**Request for Comments – Cricket NSW Centre of Excellence,
Sydney Olympic Park (SSD-10354)**

I refer to your request for comments on SSD-10354 for the development of Wilson Park for the Cricket NSW Centre of Excellence. SOPA has reviewed the Response to Submissions Report and updated supplementary report prepared by the applicant and has the following comments:

Planting Plan sheet 4

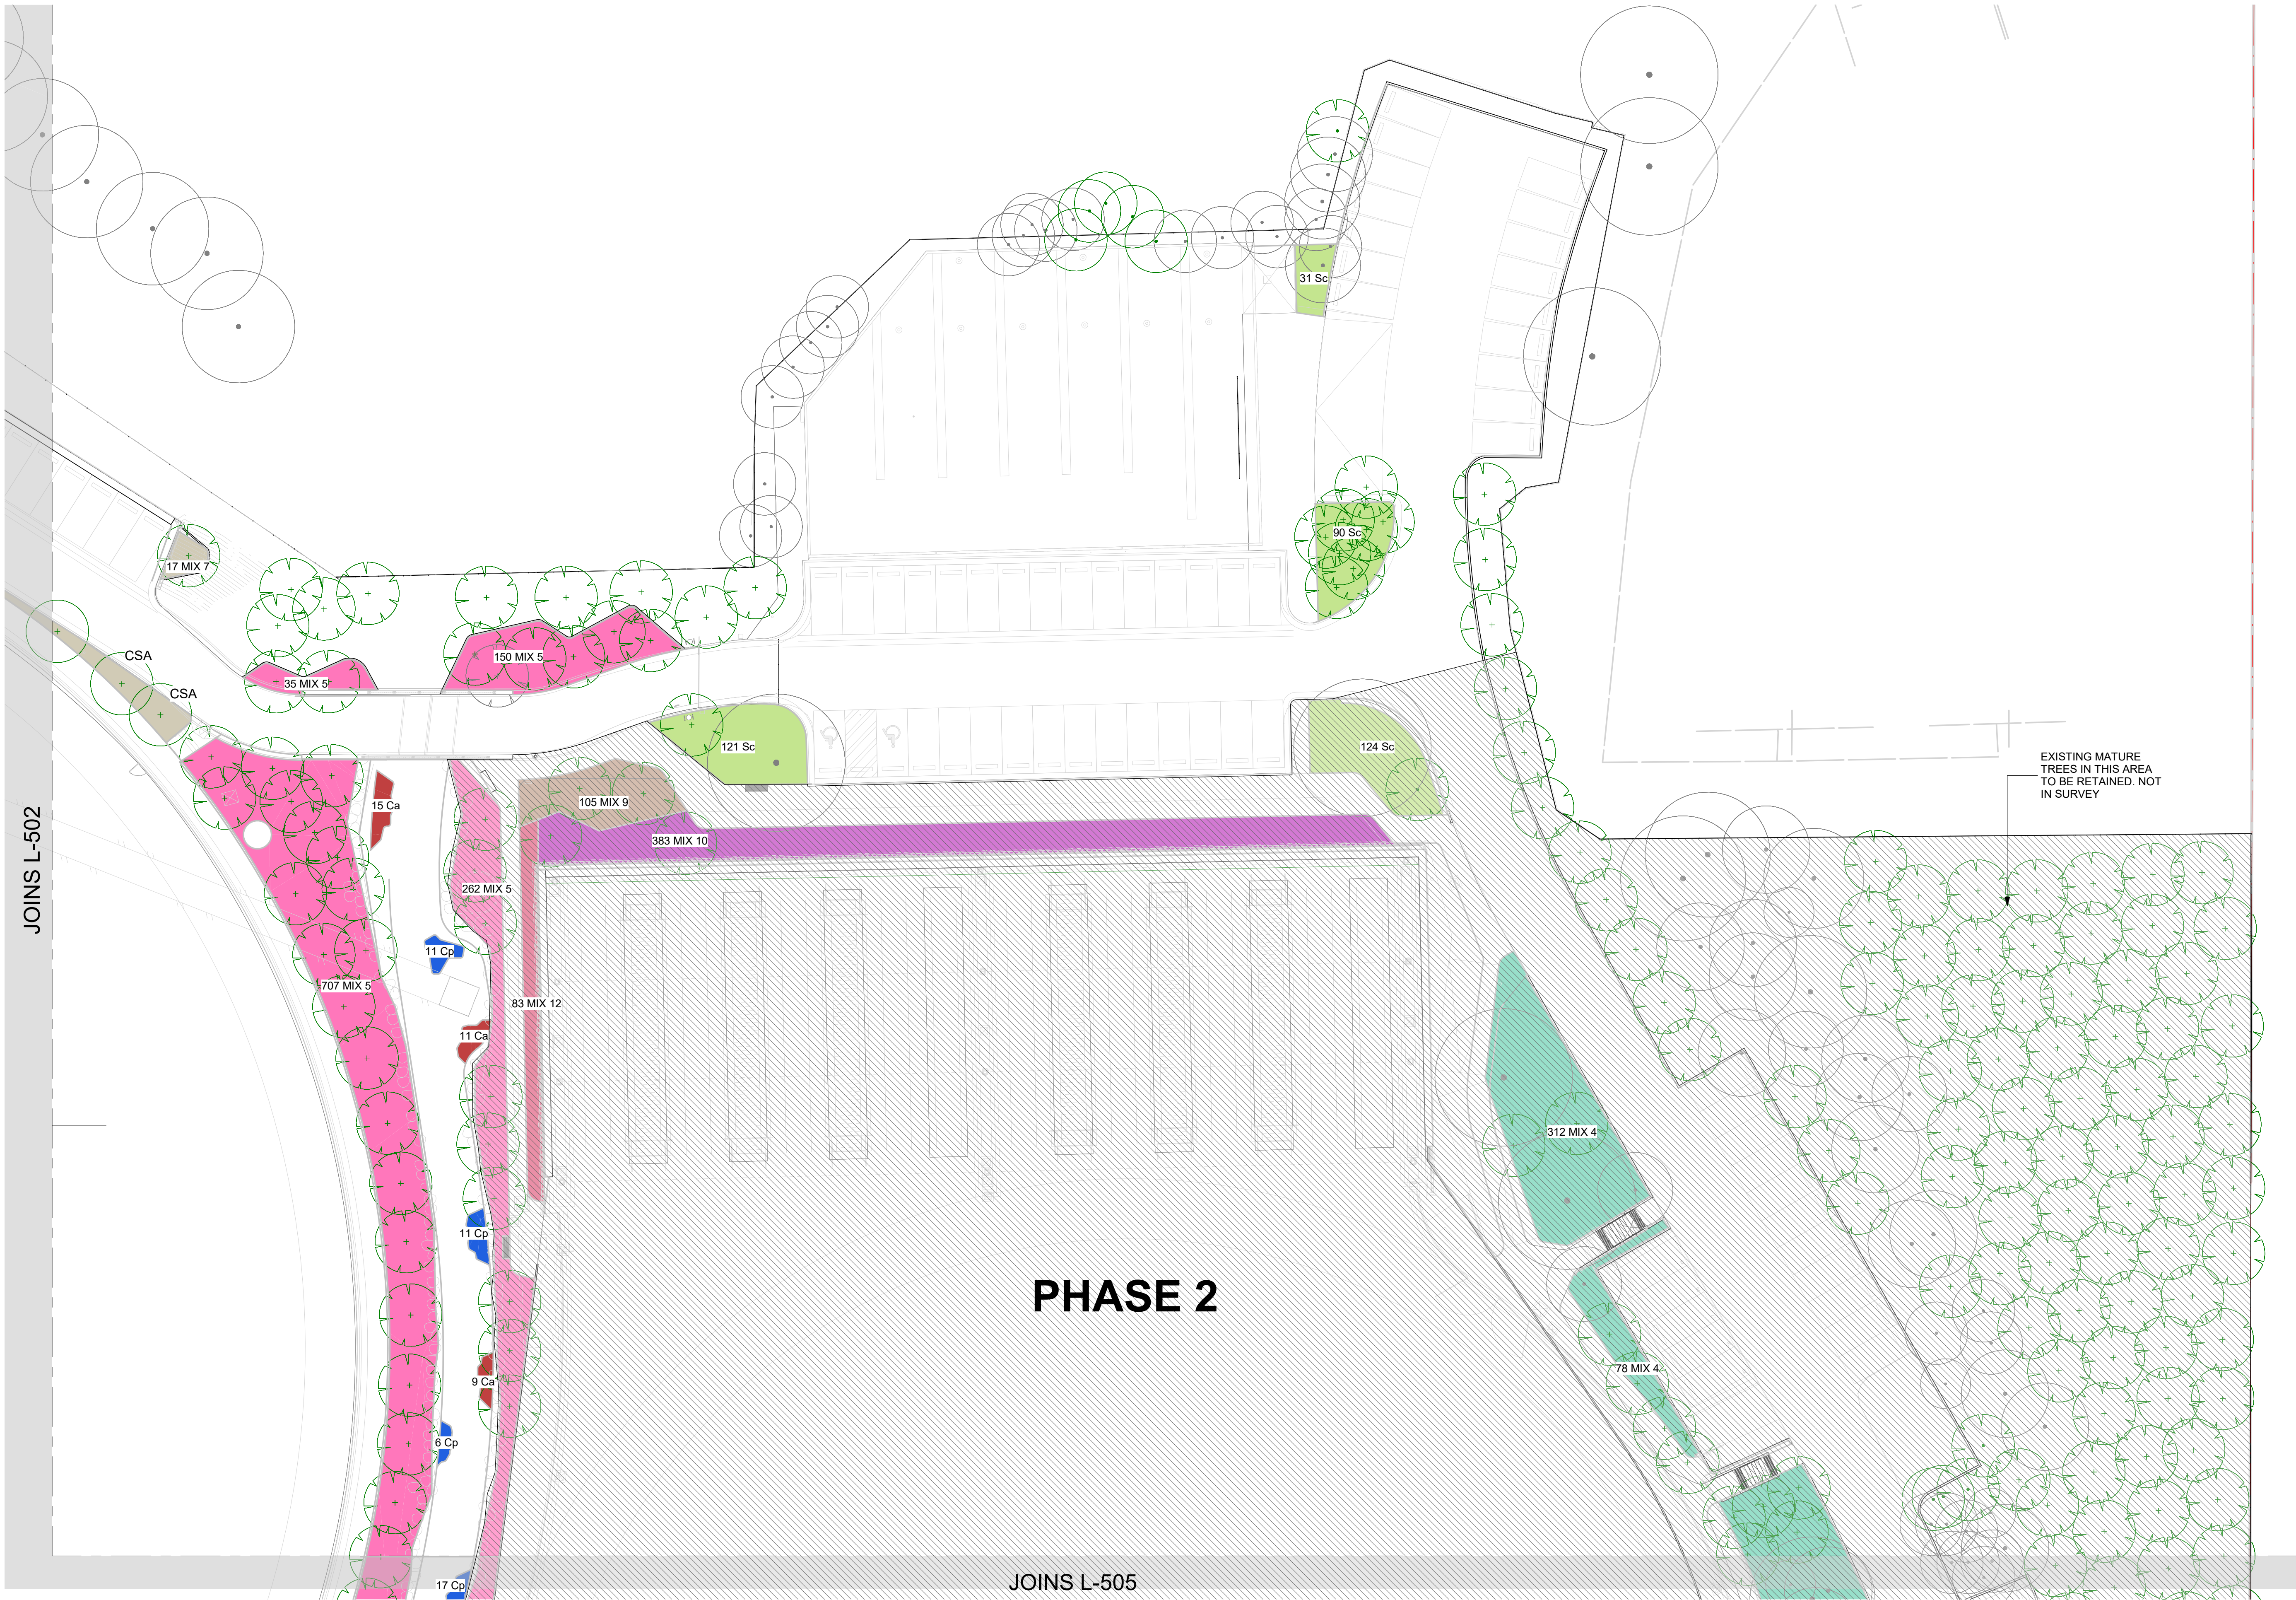
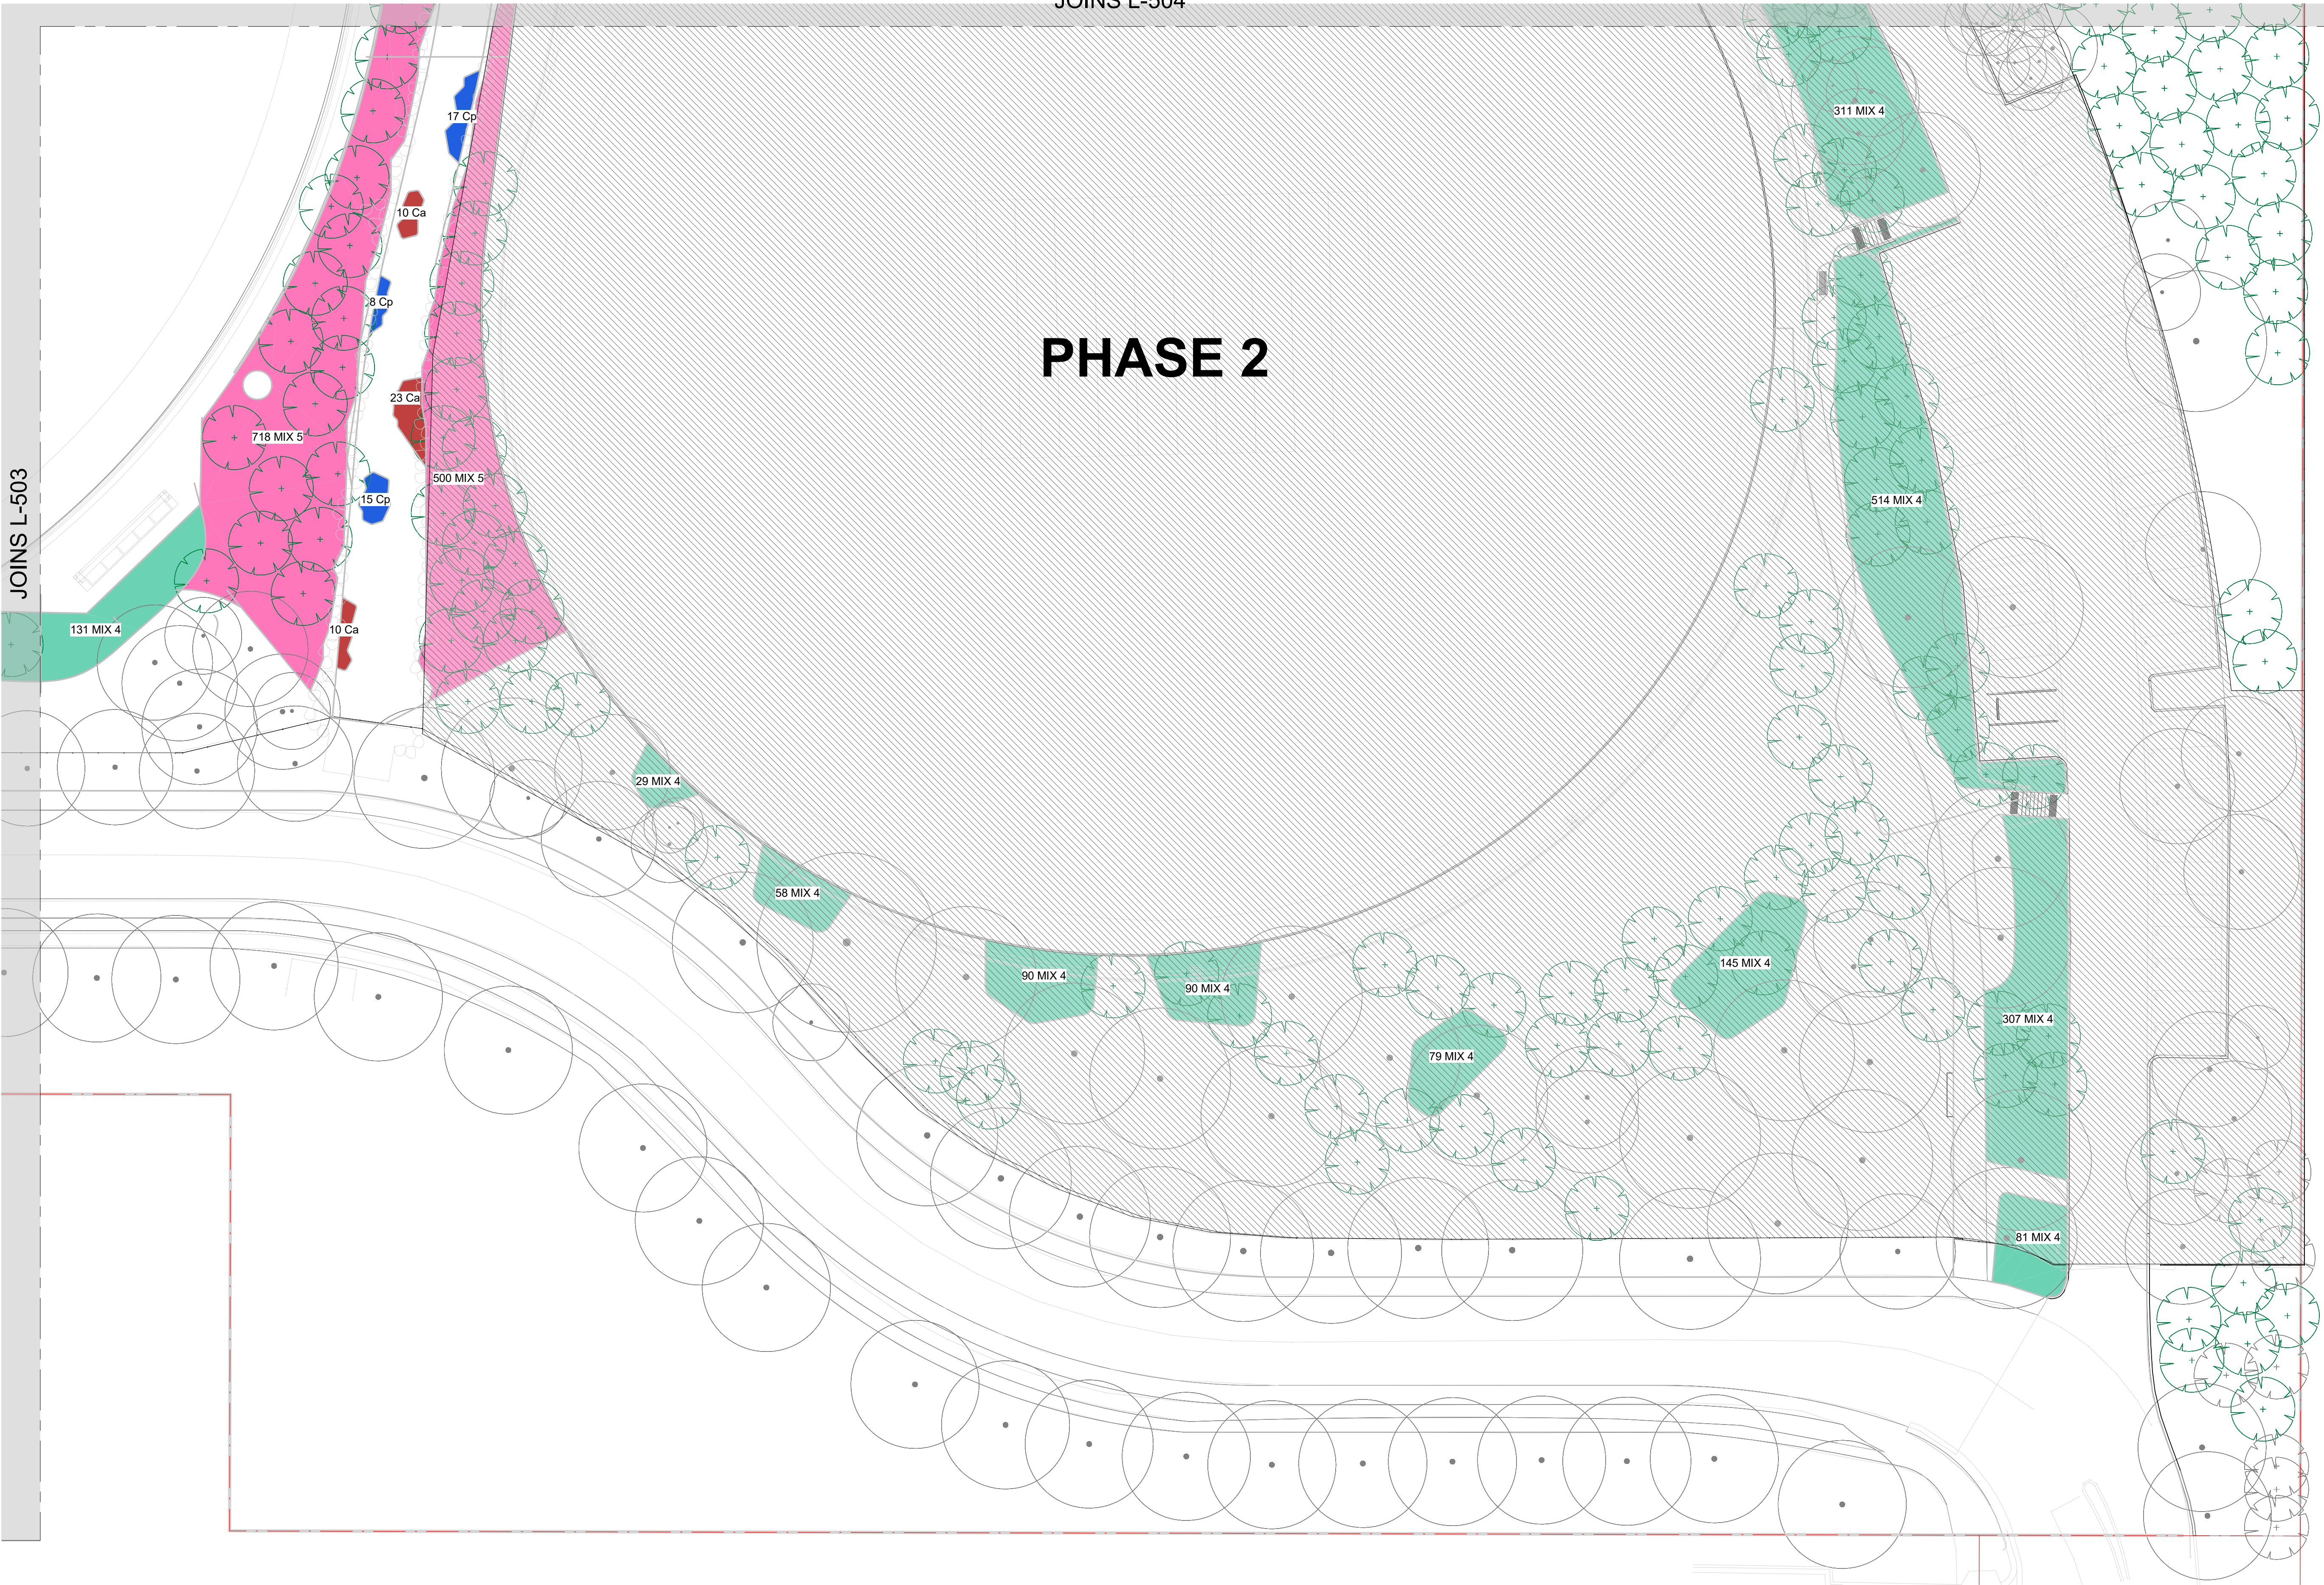
The Landscaping Report does not identify the container size of the replacement trees at planting but even in a best-case scenario, they are likely to significantly less mature than the trees they are replacing and result in a loss of tree canopy across the site. This outcome is contrary to the increased canopy targets in the Metropolis of Three Cities and Central City District Plans.

To ensure suitable replacement planting arrangements, SOPA request a condition of consent be imposed requiring that the detailed landscape plan, including planting schedule, be approved by SOPA's Director, Environment and Planning prior to the issue of the relevant Construction Certificate.
